Item No. **Report of the Head of Planning, Building Control, Sport & Green Spaces**

Address 82 MELLOW LANE EAST HAYES

Development: Two storey, 3-bed, detached dwelling with associated parking and amenity space and two storey side extension to existing dwelling

LBH Ref Nos: **69325/APP/2015/2438**

site: New House at 82 Mellow Lane East Hayes End Middx. UB4 8ER	Revisions 	boucher associates
drawing: Existing & Proposed Site Plan	 	
Scale: 1:250 Date: July 2008	Drawing No: 08/495/01	
		TEL: 01344 883639 e-mail: d.boucher@virgin.net

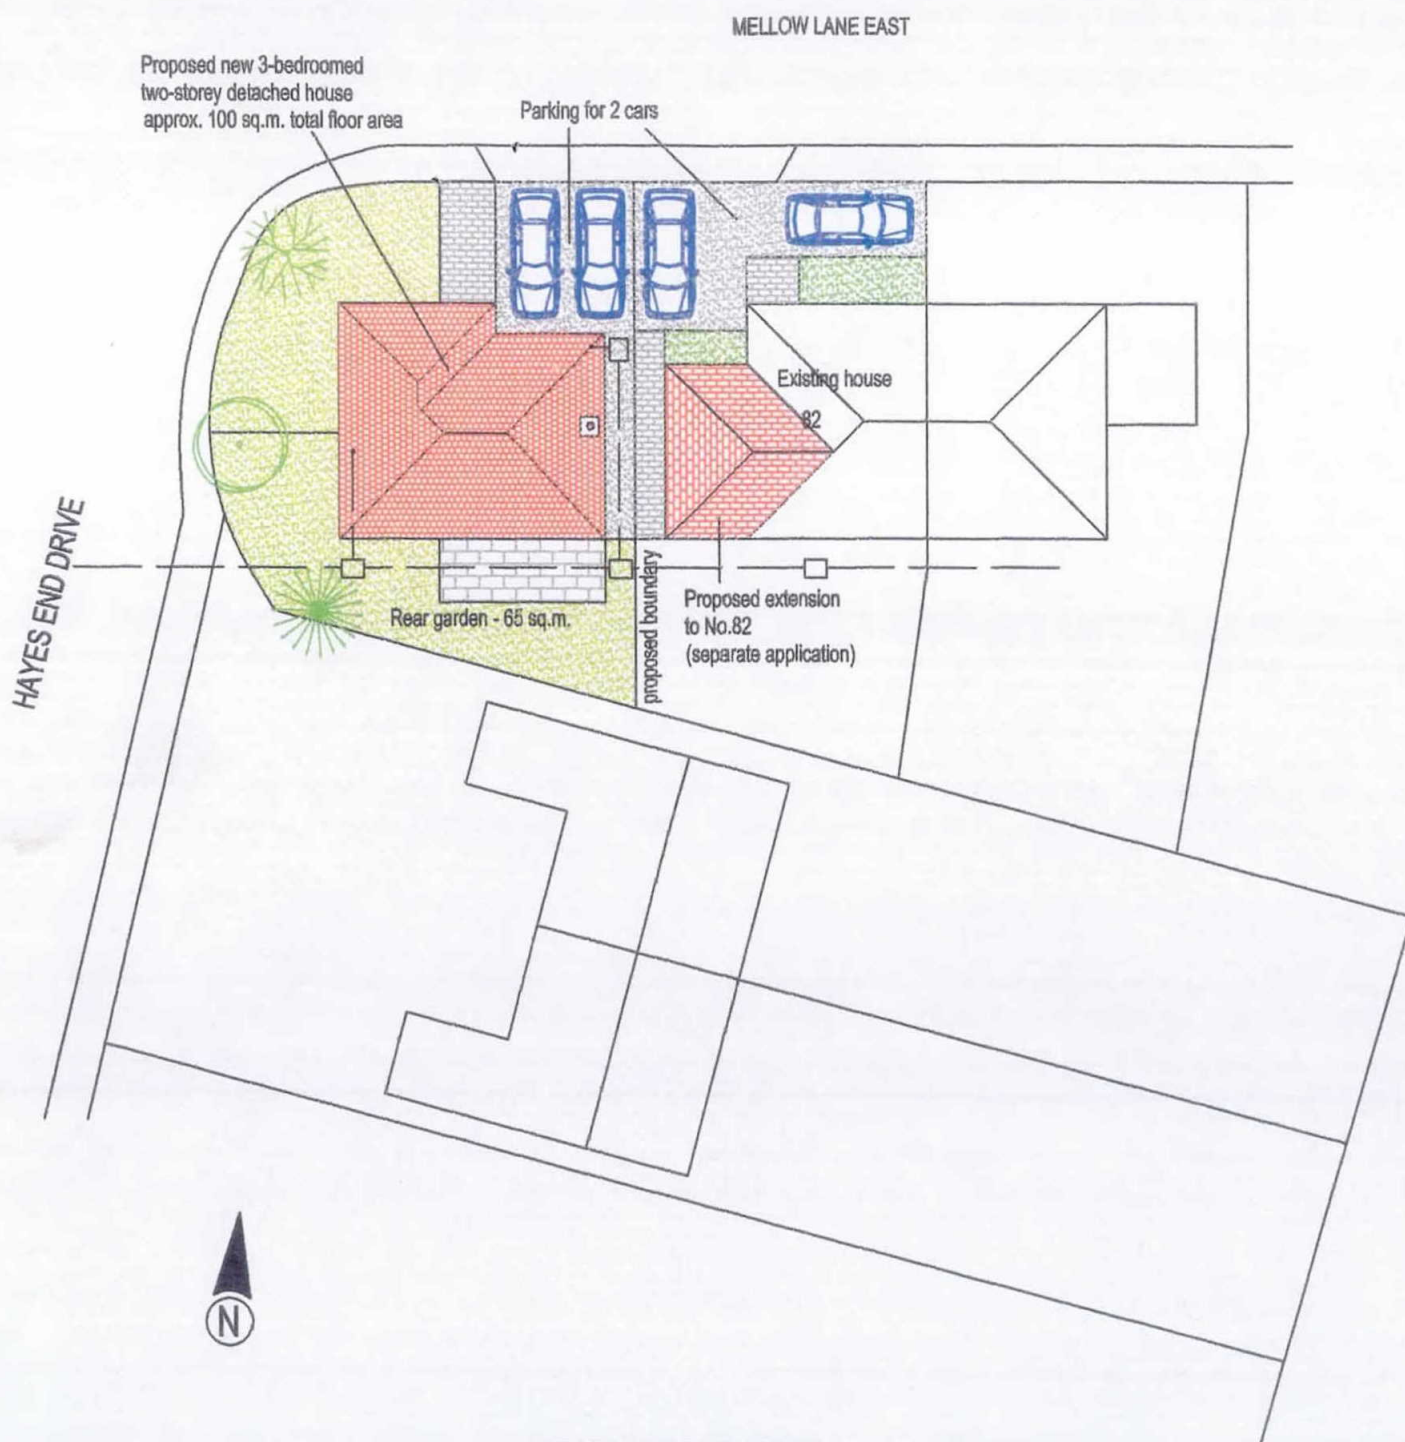
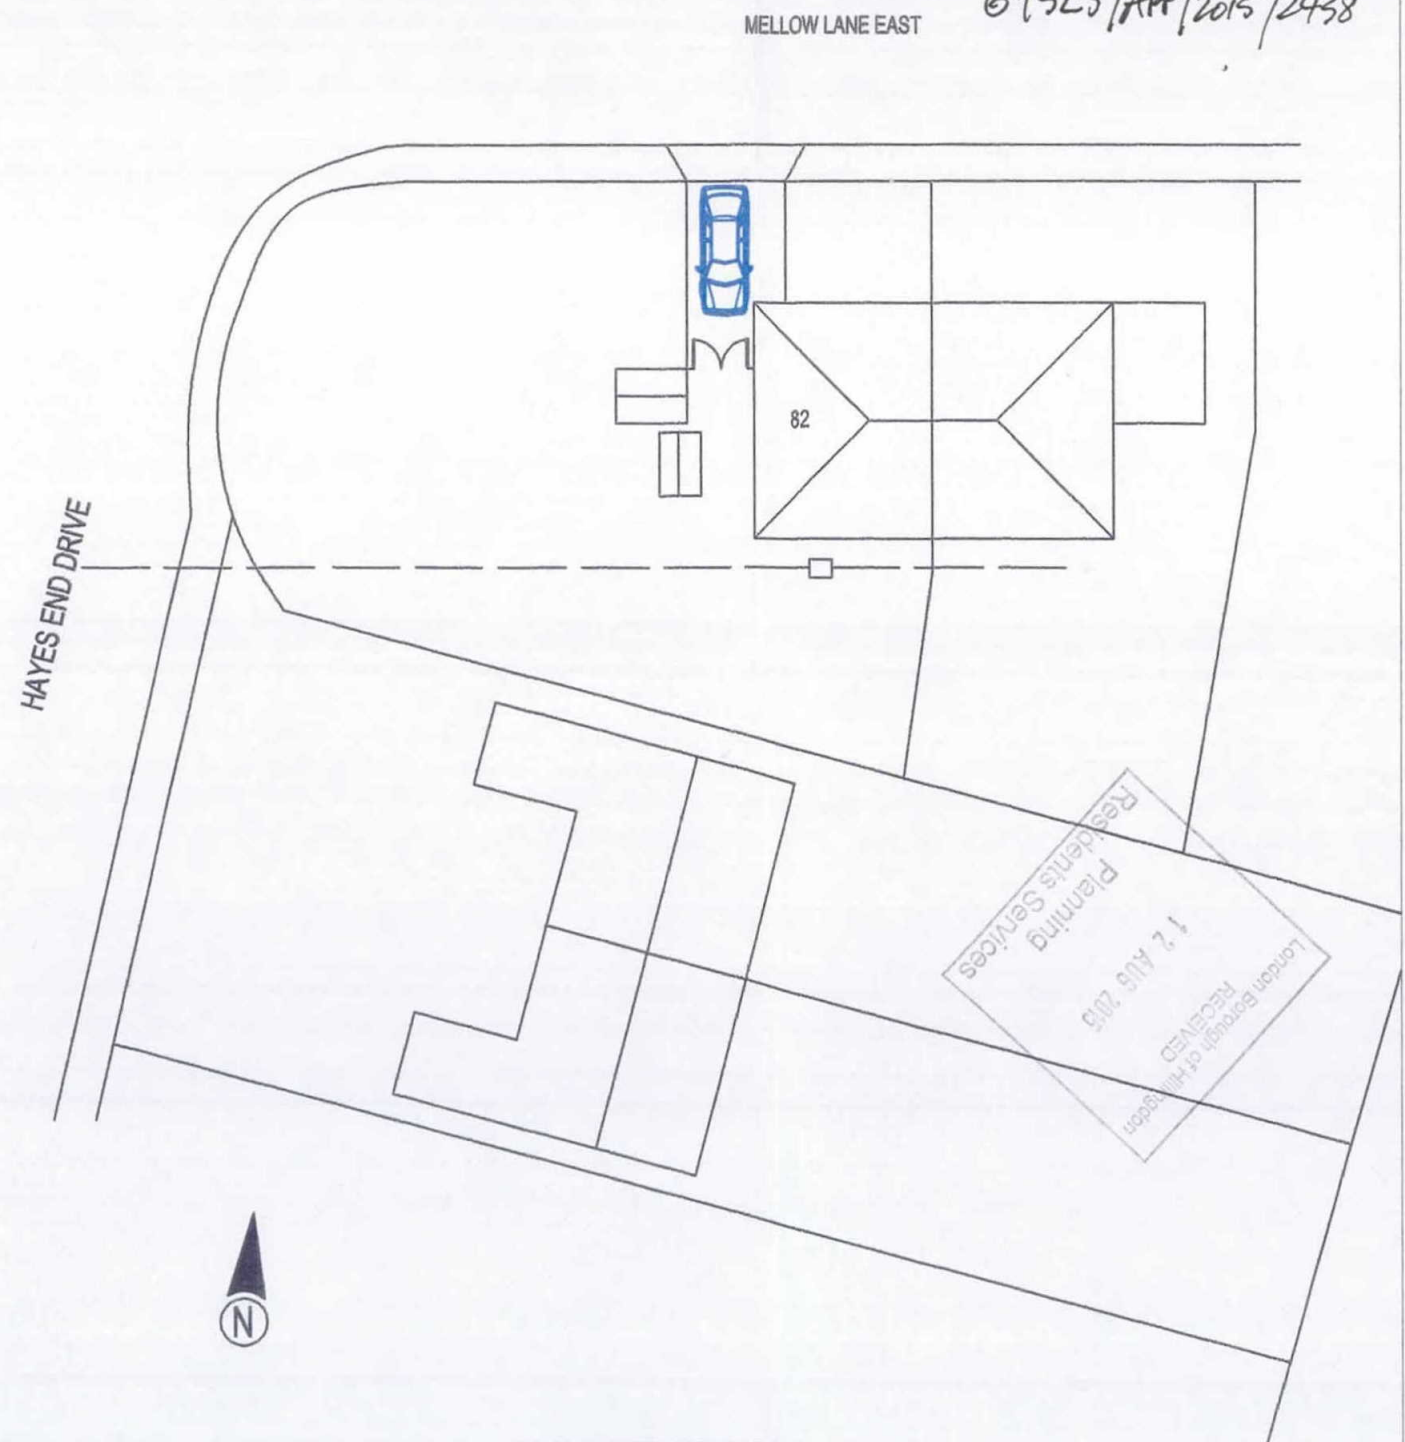
The proposed detached dwelling, by reason of its size, scale, bulk, siting in an open prominent corner position and projection forward of the return front building line on Hayes End Drive, would result in the loss of an important and distinctive spacious gap characteristic to the area, resulting in a cramped appearance. The proposal would therefore represent an over-development of the site to the detriment of the character and the visual amenities of the area and to this existing open area of the street scene. Therefore the proposal is contrary to Policy BE1 of the Hillingdon Local Plan: Part One - Strategic Policies (November 2012), Policies BE13 and BE15 of the Hillingdon Local Plan: Part Two - Saved UDP Policies (November 2012), Policies 3.5 and 7.4 of The London Plan (2015) and the adopted Supplementary Planning Document HDAS: Residential Layouts.

The proposal, by reason of the sub-division of the site and its coverage by both the existing and proposed dwellings, would fail to provide usable amenity space of sufficient area and quality commensurate to the size and layout of the extended host dwelling (82 Mellow Lane East). As such the proposal would provide a substandard form of accommodation for current and future occupiers of the existing dwelling, contrary to Policy BE23 of the Hillingdon Local Plan: Part Two - Saved UDP Policies (November 2012), the adopted Supplementary Planning Documents HDAS: Residential Layouts and HDAS: Residential Extensions.

The proposed development, by reason of the siting and excessive width of the proposed cross over when combined with the existing and the layout of the proposed parking would

With regards to the proposed two-storey detached dwelling, it is instructive to note that the overall stepped width of 9m for the dwelling is such that it would be 3m wider than the existing dwelling on the site. Notwithstanding the set-in of 4m of the proposed dwelling from the western boundary with the Hayes End Drive highway, the width of the proposed dwelling in combination with that of the existing dwelling is such that it would result in an excessive extension of the front building line along the northern boundary of what is very considerable open space on a prominent corner plot junction. As stated above in the 'Site and Locality' section, a characteristic feature of the immediate locality is corner plot/junction properties with considerable open spaces to their sides. These open spaces, together with the expansive area of woodland adjacent to the northern side of the Mellow Lane East/Hayes End Drive T junction, provide considerable visual relief in what is a densely built up area. The open space between the existing dwelling on the site and the western boundary is unusual in that it is significantly substantial than most of the open spaces in adjacent sites. It is also instructive to note that the building line on the return frontage along Hayes End Drive is fairly established in terms of uniformity. It is acknowledged that the proposed dwelling attempts to reference the established hipped roofscape and design detailing of the existing and neighbouring dwellings in the locality. However, the western side of the proposed building would protrude considerably beyond the front building line of properties fronting onto Hayes End Drive and its two storey height and overall bulk would combine to give it an incongruous and overly-dominating appearance so close to the corner junction. The proposed dwelling would have a footprint of approximately 70sq.m, which would be less than half of the area of its sub-divided site. However, its footprint and orientation on the site is such that it would have a constrained depth of 5m for its rear garden (at the furthest point). As such, the sub-division of the site to provide an additional dwelling would result in over-development of the site and a severe

site: New House at 82 Mellow Lane East Hayes End Middx. UB4 8ER	Revisions	boucher associates
drawing: Proposed Floor Plans		
Scale: 1:100 Date: Sept. 08	Drawing No: 08/495/03	TEL: 01344 883639 e-mail: d.boucher@virgin.net

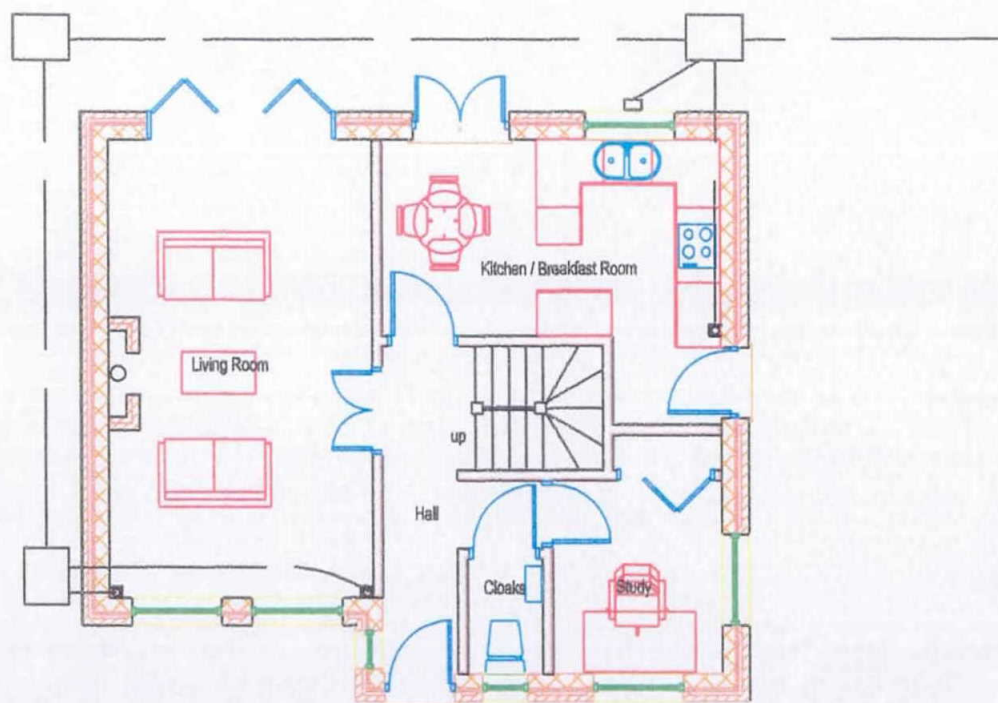
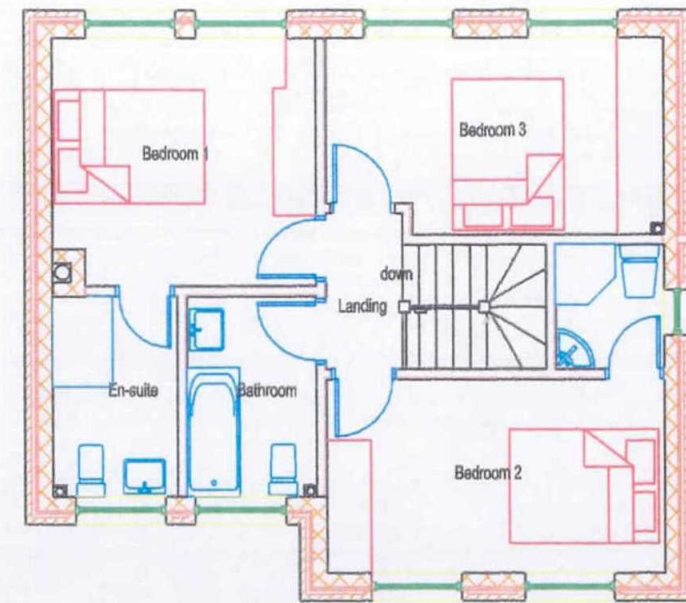
The proposed detached dwelling, by reason of very close proximity to the blank flank wall of the closest adjacent property to the rear at No. 84 Hayes End Road, would result in severely restricted outlook from ground and first floor habitable windows, thereby failing to provide a satisfactory standard of internal living environment for the benefit of future occupiers of the dwelling. The proposal would therefore give rise to a substandard form of living accommodation to the detriment of the amenities of future occupiers, contrary to Policy 3.5 of The London Plan (2015), Policies BE19, BE20 and BE21 of the Hillingdon Local Plan: Part Two - Saved UDP Policies (November 2012) and the adopted Supplementary Planning Document HDAS: Residential Layouts.

However, and as stated in the above 'Impact on Neighbours' section, the proposed dwelling would have ground and upper floor rear windows serving habitable living room/kitchen/dining room and bedroom windows. These rear windows would be sited 5m and 6m away (at the nearest and furthest points) from the blank northern flank wall of the closest adjacent property to the rear at No. 84 Hayes End Drive. The very close proximity of the rear windows to the flank wall of the adjacent property is such that it would result in severely restricted outlook for any future potential occupants from those habitable windows. Given that the proposed dwelling would not result in the proposed habitable rooms maintaining an adequate outlook, the proposal would fail to provide a satisfactory living environment for future occupants and would be contrary to the requirements of the HDAS SPD: Residential Layouts (July 2006), Policy BE20 of the Hillingdon Local Plan: Part Two - Saved UDP Policies (November 2012) and Policy 3.5 of The London Plan (2011)

drawing: 08/495-09

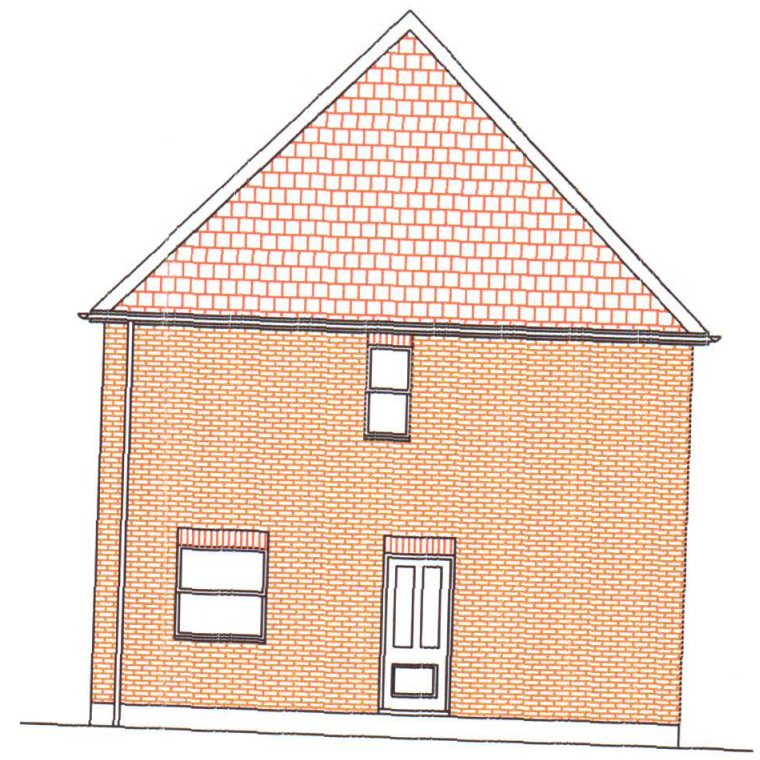
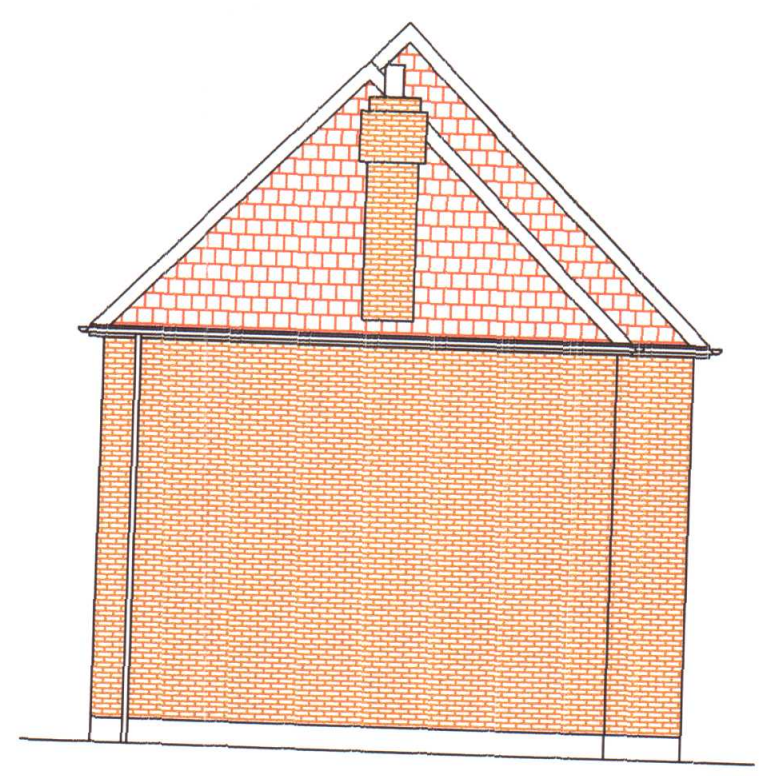
The proposed detached dwelling, by reason of its size, scale, bulk, projection forward of the return front building line on Hayes End Drive and inadequate separation distance between it and the closest adjacent property at No. 84 Hayes End Drive, would result in an unacceptable level of overlooking, overbearing and over-dominating impact on that adjacent property, to the detriment of the visual and residential amenities of occupants of that property, contrary to Policies BE19, BE20 and BE21 of the Hillingdon Local Plan: Part Two - Saved UDP Policies (November 2012) and the adopted Supplementary Planning Document HDAS: Residential Layouts (July 2006).

The proposed dwelling would also maintain the rear building line of the existing dwelling. However, the proposed dwelling would project beyond the closest adjacent dwelling on the return building line that fronts Hayes End Drive, No. 84 Hayes End Drive. The proposed dwelling would have a shorter rear garden than the retained garden for the existing dwelling (in terms of depth), and its rear elevation would be set away from the rear (southern) boundary with No. 84 Hayes End Drive by 3m and 5m at the nearest and furthest points respectively. The proposed dwelling would be significantly less than the required minimum 15m separation distance, and the very close proximity of ground and first floor rear windows in the proposed dwelling to the rear boundary is such that they would not maintain an acceptable degree of separation between adjacent No. 84 Hayes End Drive. The very close proximity of the rear facing windows to the rear boundary is such that they would result in an unacceptable level of overlooking and overshadowing of the front garden and northern flank wall of No. 84 Hayes End Drive. As will be highlighted in a later section, the close proximity of the rear windows to the blank flank wall of the adjacent property is such that it would result in severely restricted outlook from those windows.

Given the above considerations, the proposed dwelling would result in an obtrusive and over-dominating appearance and an unacceptably oppressive and overbearing impact on the occupants of the closest adjacent property at No. 84 Hayes End Drive. As a result of not maintaining adequate separation distances to the adjacent property, the proposed dwelling would result in direct overlooking and unacceptable loss of privacy to that neighbouring property, contrary to Policies BE19, BE20, BE21, BE22 and BE24 of the Hillingdon Local Plan: Part Two - Saved UDP Policies (November 2012) and the related guidance in the HDAS SPD: Residential Layouts (July 2006).
